THE HILLS SHIRE COUNCIL

20 October 2017

Your Ref: SSD 8344

K-6 Public School – Nos. 120-126 Hezlett Road, Kellyville

Figure 1 Site and Catchment Map

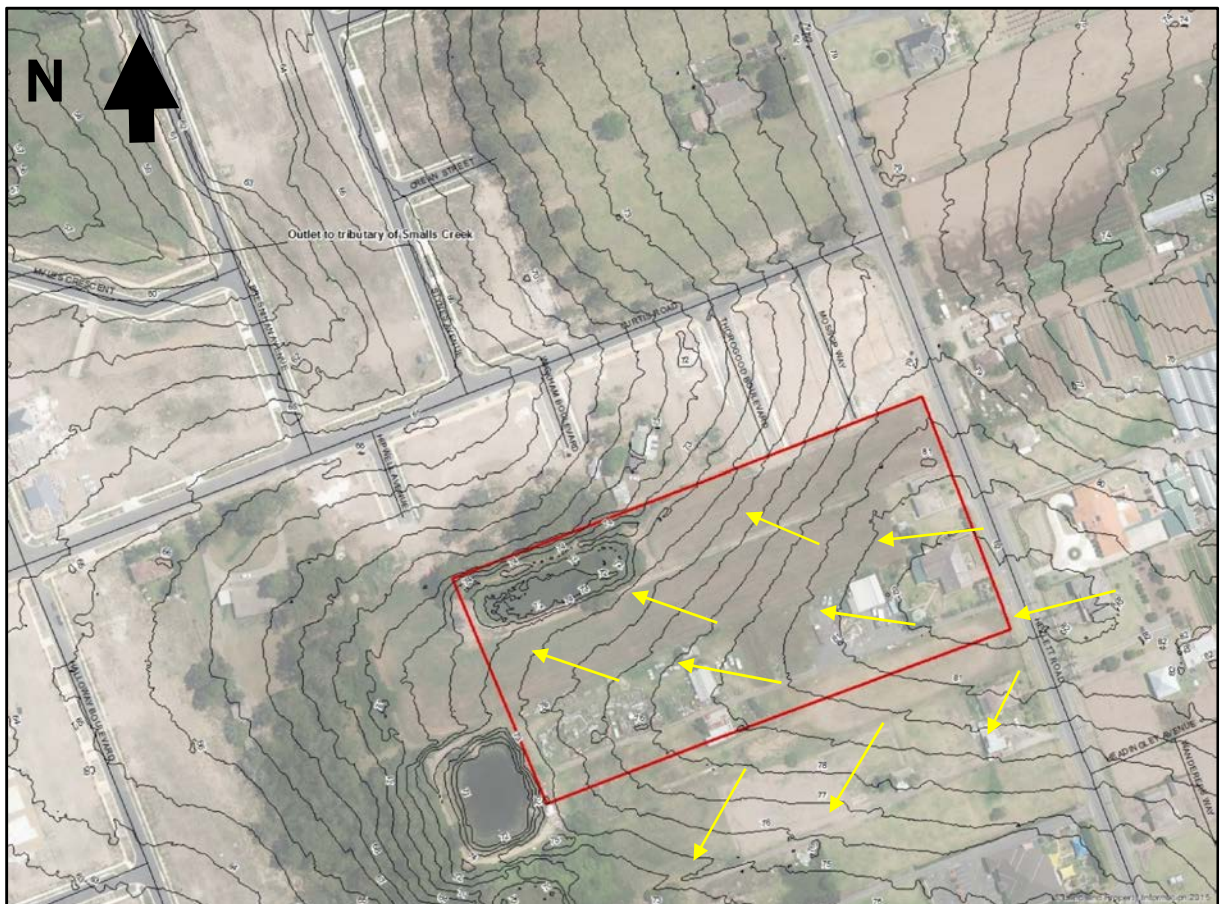
The stormwater report and the stormwater plan do not include a catchment plan or consider the upstream catchment in the design. Hipwell Avenue and Prentice Avenue, if provided as required, would serve to collect and direct runoff from upstream along these roads/ away from the development.
